Statement of Common Ground with the Environment Agency (draft)

Revision 2

October 2025

- 1.1.1 This Statement of Common Ground (hereafter referred to as the 'SoCG') has been prepared to support the Examination of the Development Consent Order (DCO) application (the 'DCO Application') for Peartree Hill Solar Farm (the 'Proposed Development').

#### Figure 3.6: Indicative Culvert Crossing Points

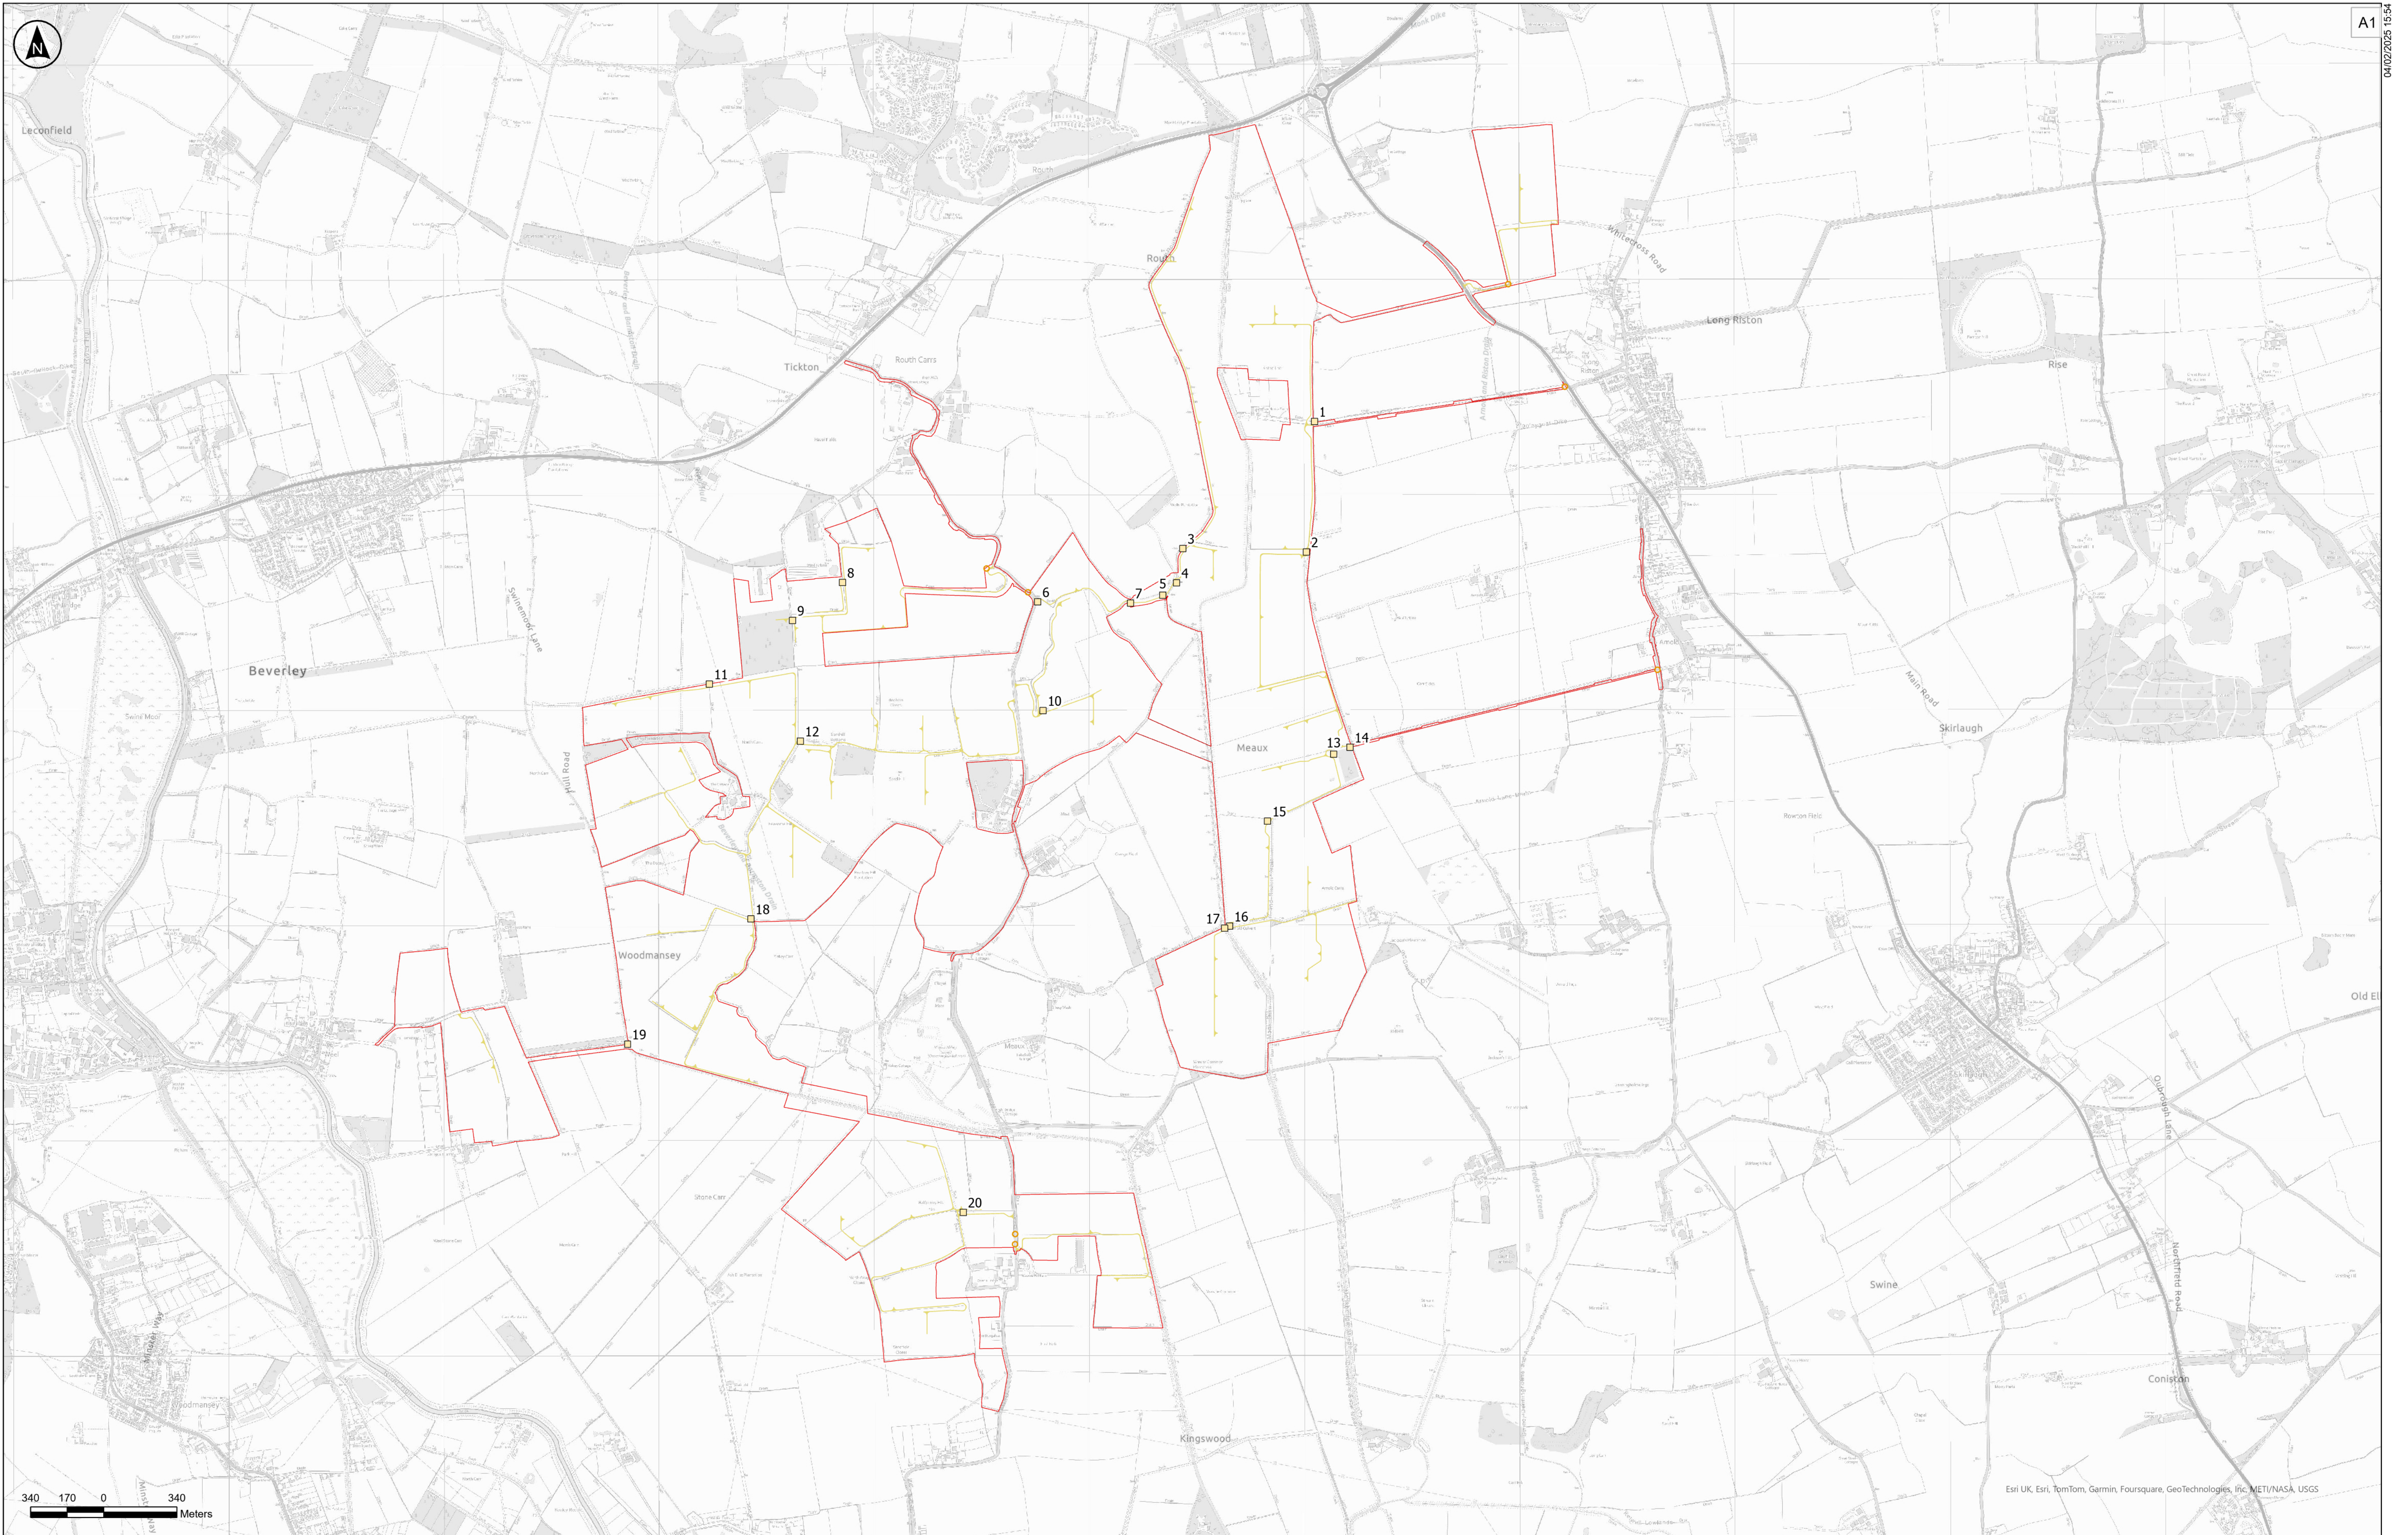
Ref	Topic	Environment Agency's Position	Applicant's Position	Status
EA23	Use of Culverts <i>Hydrology and Flood Risk</i>	In their Comments on the Deadline 1 Submissions [REP2-153] (EA06), the Environment Agency reiterated its request that the Applicant should avoid the use of culverts wherever possible. The Environment Agency welcomes the Applicant's intention to utilise existing culverts or bridges where possible and that for the purposes of the assessment it has been assumed that all existing crossings will require a new culvert structure. The Environment Agency advises that if any existing box or pipe culvert crossings are found to be unsuitable, they should be upgraded to a portal/3-sided/arch culvert or to a larger box culvert with mammal ledge and be of a size that does not restrict the passage of water. There should be robust (geomorphic) reasons for the use of piped/box culverts. The Environment Agency reiterates that all crossings should be considered on a case-by-case basis following surveys,	This response is noted and as per the Applicant's Response to Relevant Representations [REP1-071], the choice of crossings is subject to detailed surveys and investigations. The preferred method will be agreed with the Environment Agency at the detailed design stage via the Protected Provisions in Part 4 of Schedule 12 to the Draft DCO [EN010157/APP/3.1 Revision 7]. Box culverts were presumed to be utilised for the purposes of the assessments (such as ES Volume 4, Appendix 5.5: Water Framework Directive Screening and Scoping [REP1-030]) to follow a precautionary approach. It is the Applicant's intention to utilise existing culvert crossings and/or bridge structures where possible. For the purposes of the assessment, 20 locations (see ES Volume 3, Figure 3.6: Indicative Culvert Crossing Points [REP2-093]) are assumed to require either the installation of a temporary span bridge or culvert, or reinforcement or widening of the existing culvert/bridge structure. To ensure a worst-case scenario has been assessed, it has been assumed that all existing crossings will require a new culvert structure. It is however expected that	Under discussion

Ref	Topic	Environment Agency's Position	Applicant's Position	Status
		not just of structural strength, but of habitat and conservation value, including geomorphological activity. In addition, the Environment Agency notes that the cumulative impact of potentially culverting rivers in multiple locations should be considered.	following pre-construction structural surveys the number of new culverts required would be lower. The crossings over minor watercourses, which are likely to be wet for much of the year, would be facilitated by box culverts. These would be fitted with a mammal shelf and the bed substrate would match that of the watercourse within the vicinity of the crossing.	
EA24	Culverts – Post Decommissioning <i>Hydrology and Flood Risk</i>	In their Comments on the Deadline 1 Submissions [REP2-153] (EA07), the Environment Agency reiterated its concerns around proposals to potentially leave culverts in-situ after decommissioning. The Environment Agency stated that it would like to see a commitment to remove any crossings that have no further use and that given the potential change in environment at point of decommissioning, the options for removal or leaving them in situ should be considered within the DEMP.	As set out in the Applicant's Response to Relevant Representations [REP1-071], the choice of crossing type at each proposed crossing location will be subject to detailed surveys and investigations. The preferred method will be agreed with the Environment Agency. For the purposes of the assessments (such as in ES Volume 4, Appendix 5.5: Water Framework Directive Screening and Scoping [REP1-030]), box culverts were assumed to be utilised at each location in order to follow a precautionary approach. The Applicant notes the Environment Agency's request to remove crossings no longer needed. As recommended by the Environment Agency, this would be assessed ahead of decommissioning using the policy and legislative	Under discussion
